Online Comment

Application	H21-1250-21
Location	Land West of 1 East Road Tydd Gote Wisbech
Proposal	Proposed Demolition of Existing Office and Erection of 2 x 1 bed dwellings

Name	Greg Watkinson
Address	Conservation Officer

Date Submitted	07-12-21
For/Against	Comments

Planning Front
1 : 100

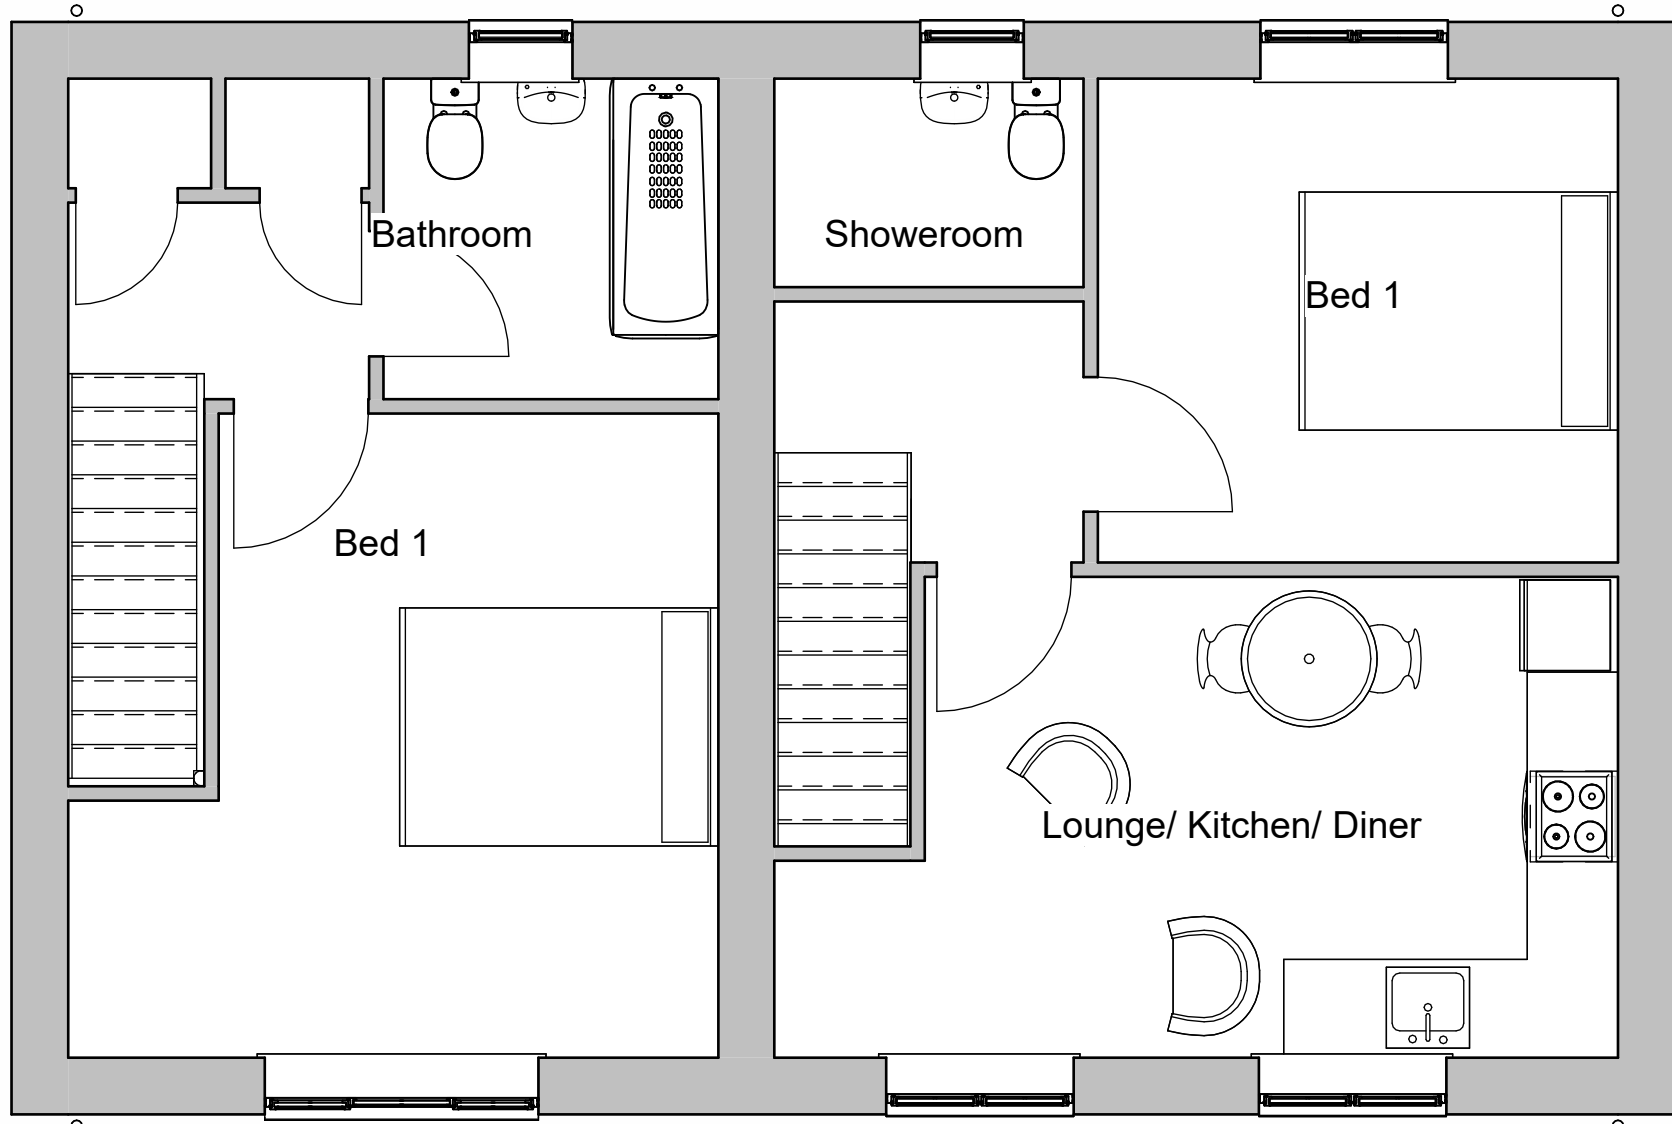
In general, the proposed design of the properties is relatively simple, although it does match similar properties immediately adjacent and within the wider area. However, I note that the applicant has indicated that UPVC windows and doors and concrete roof tiles will be used - this is unacceptable within a Conservation Area setting, particularly in relation to development which would be so readily visible from the public realm, and is at odds with the character of surrounding development. The applicant should be required to make use of vernacular materials, particularly via the use of timber windows and doors and traditional roofing materials, in order to allow the proposal to respect the local character and setting through the use of appropriate materials, as is a requirement of Policy 29 of the South East Lincolnshire Local Plan (2019).
